Application Reference: 2025/1078

Site Address: 3 Warner Road, Pogmoor, Barnsley, S75 2HQ

Proposal: Single storey rear extension

Drawing Title
PROPOSED ELEVATIONS

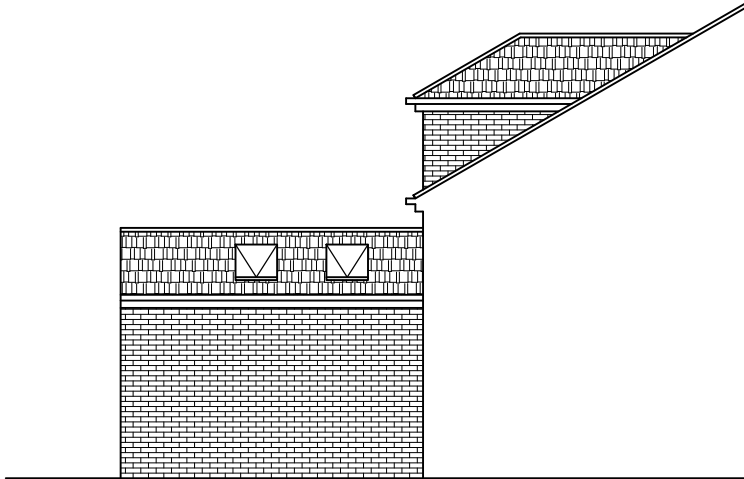
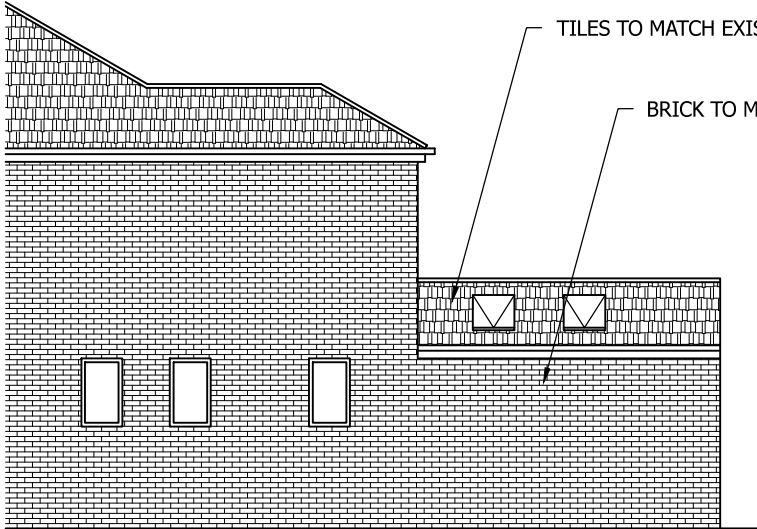
The proposed extension projects to the rear of the dwelling by approximately 4 metres and is therefore compliant with the House Extensions SPD and is a similar projection to other extension in the area. The proposal provides a gable roof form which is in keeping with the site and a reduced eaves height of 2.3 metres and is less than the maximum 2.5 metres allowed under the House Extensions SPD. The rear elevation glazing is detailed centrally and symmetrically to the extension. The use of matching materials allows the proposal to remain in keeping with the character of the dwelling.

The use of a pitched roof form significantly reduces the potential for the proposal to impact the neighbouring dwelling by causing a loss of light or overshadowing, providing an eaves height of 2.3 metres nearest to the boundary. A 2.3 eaves height is considered low level and would only be 0.3 metre higher than a 2-metre-high boundary wall which could be erected under permitted development. Additionally, the proposal would be located predominantly to the southeast of the adjoined property, restricting any loss of light predominantly to the mornings. The overshadowing from the proposal would also cast the greatest shadow over its own property and not the neighbouring amenity space.

No side windows are detailed to the proposal, preventing any opportunity for overlooking and the existing boundary treatment assists in screening the proposal.
